Subject: 32 Dauphine Street
Fuquay Varina, NC 27526
Plan Revision Letter #2
Harnett County Permit #: SFD2308-0046

Based on the request of the Contractor, 1 item on the plans will be revised. My assessment and recommendations are as follows:

Crawl Space Foundation Plan

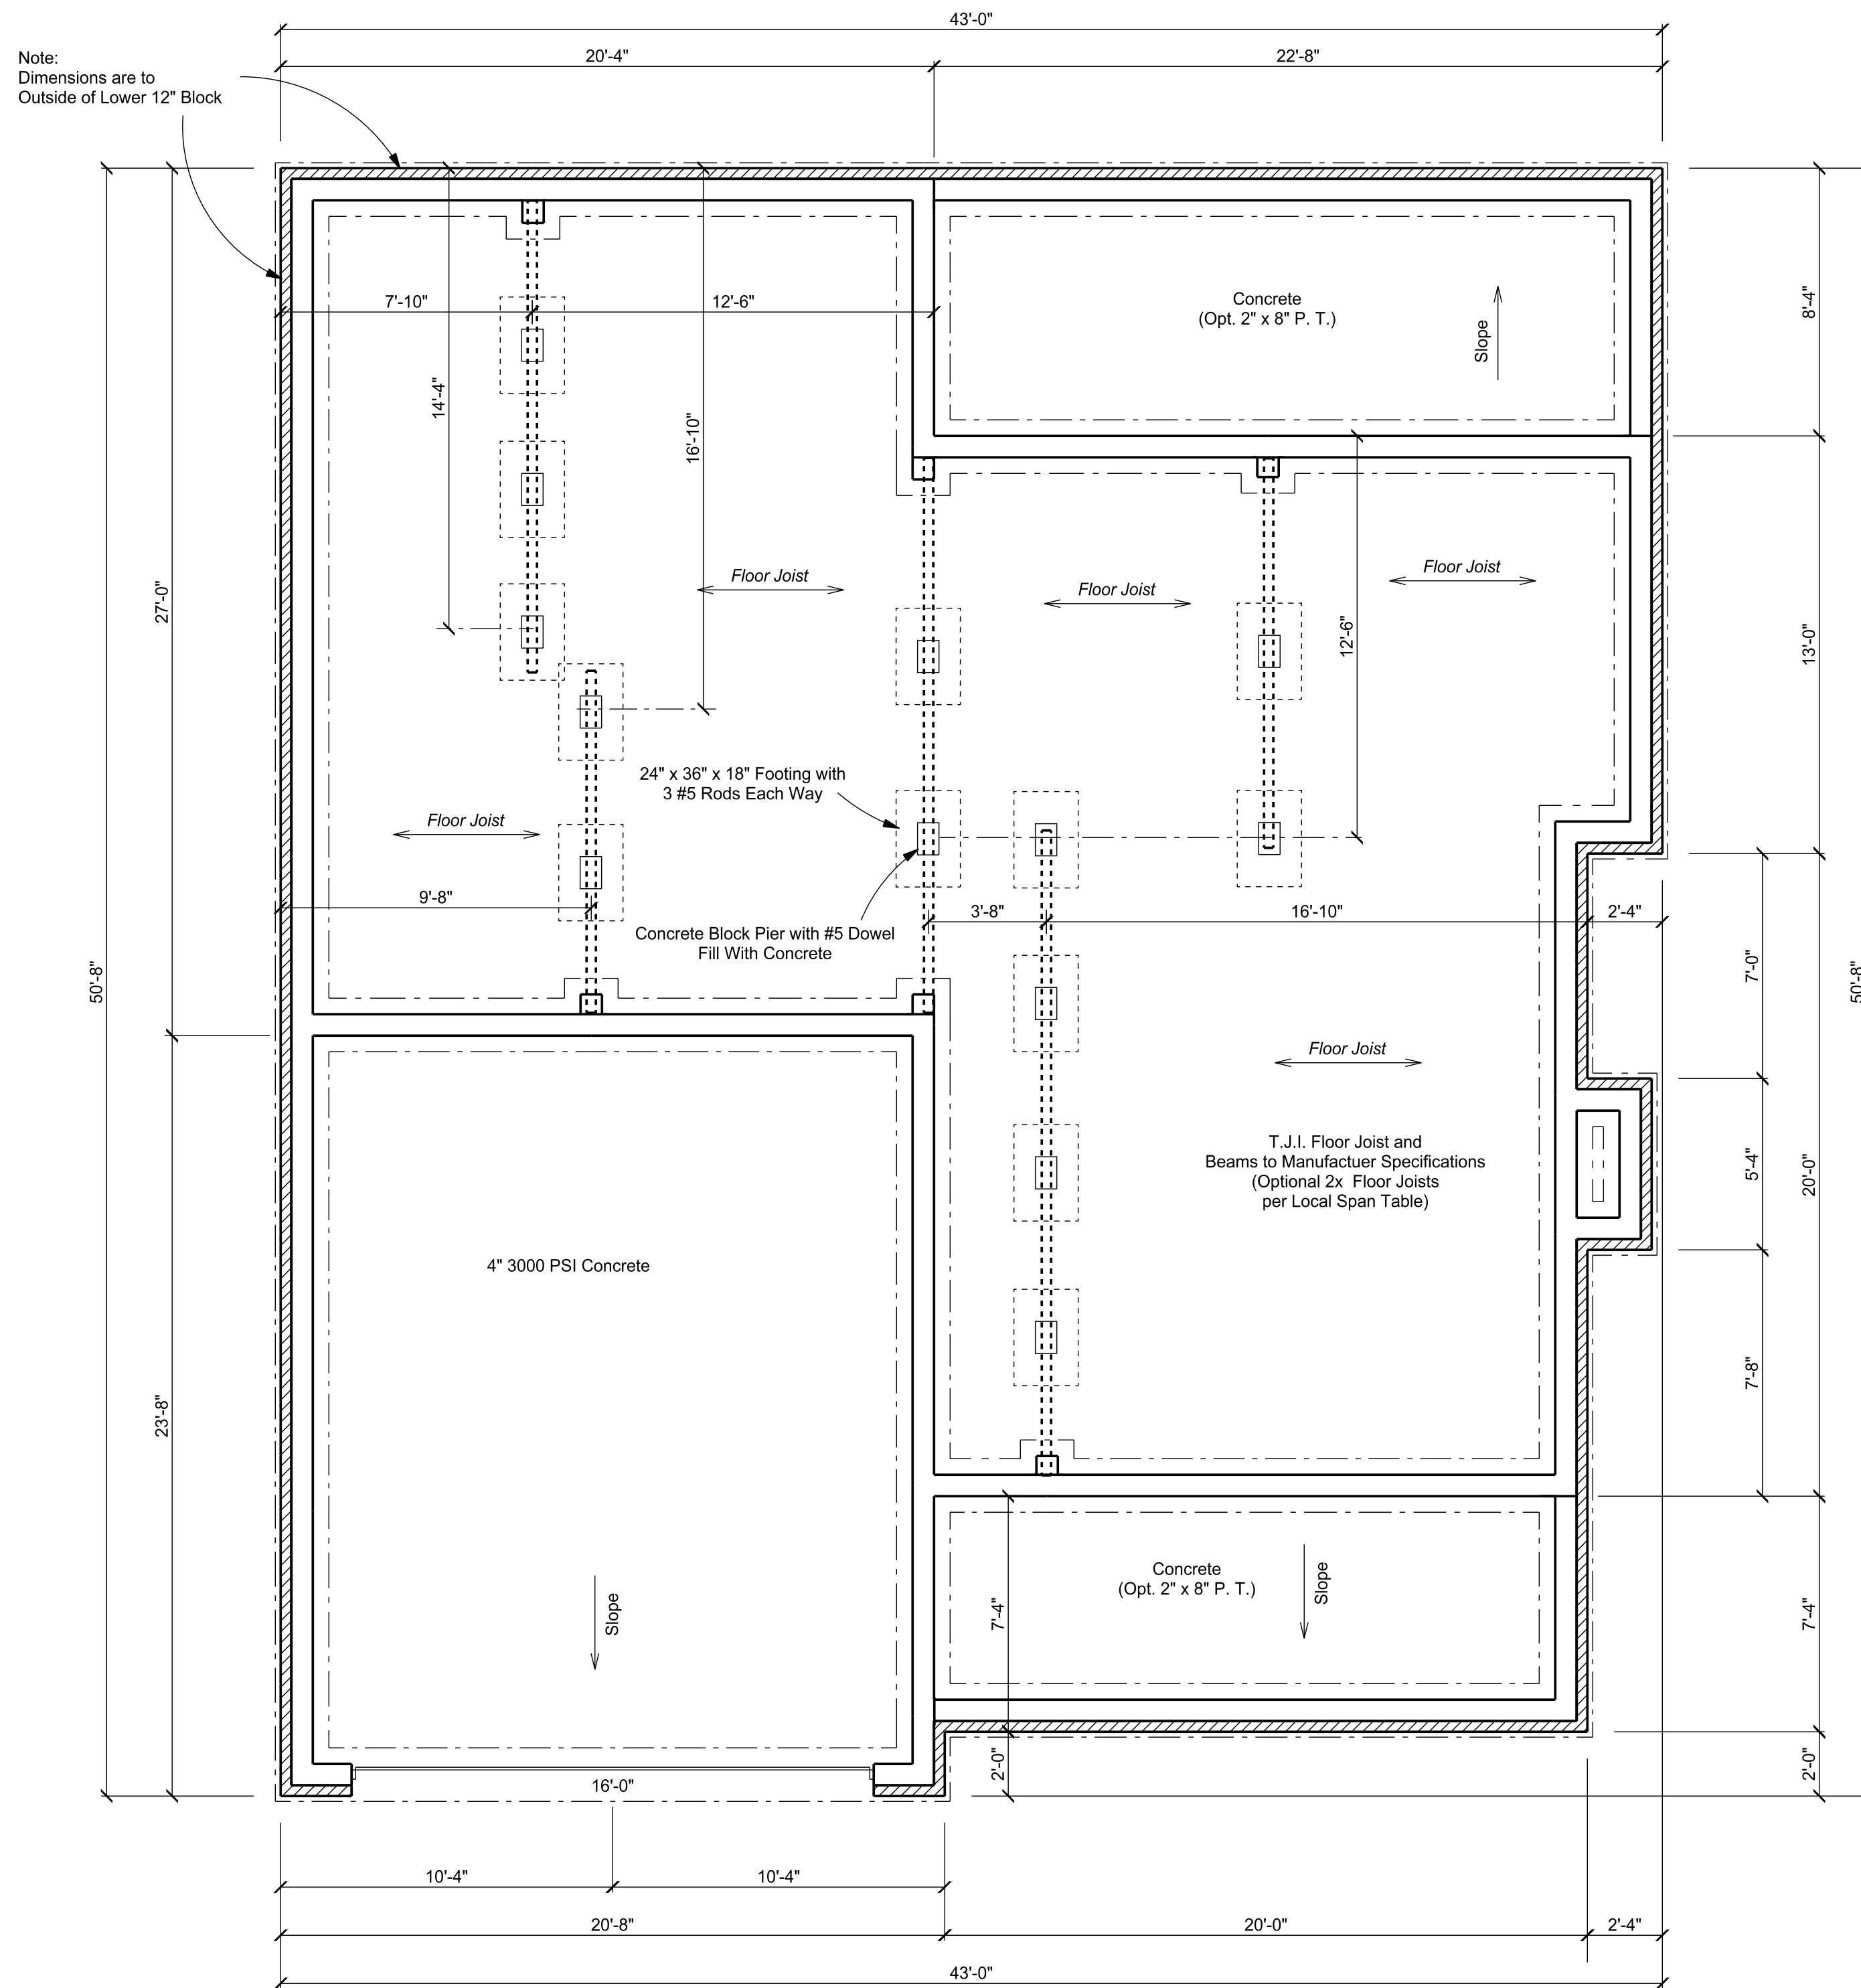
- Item 1 – The support beams in the crawlspace were specified as 2-2x12 members in the plans. The Contractor would like to use a triple 2x10 beam in lieu of the double 2x12 beam. This beam substitution is acceptable.
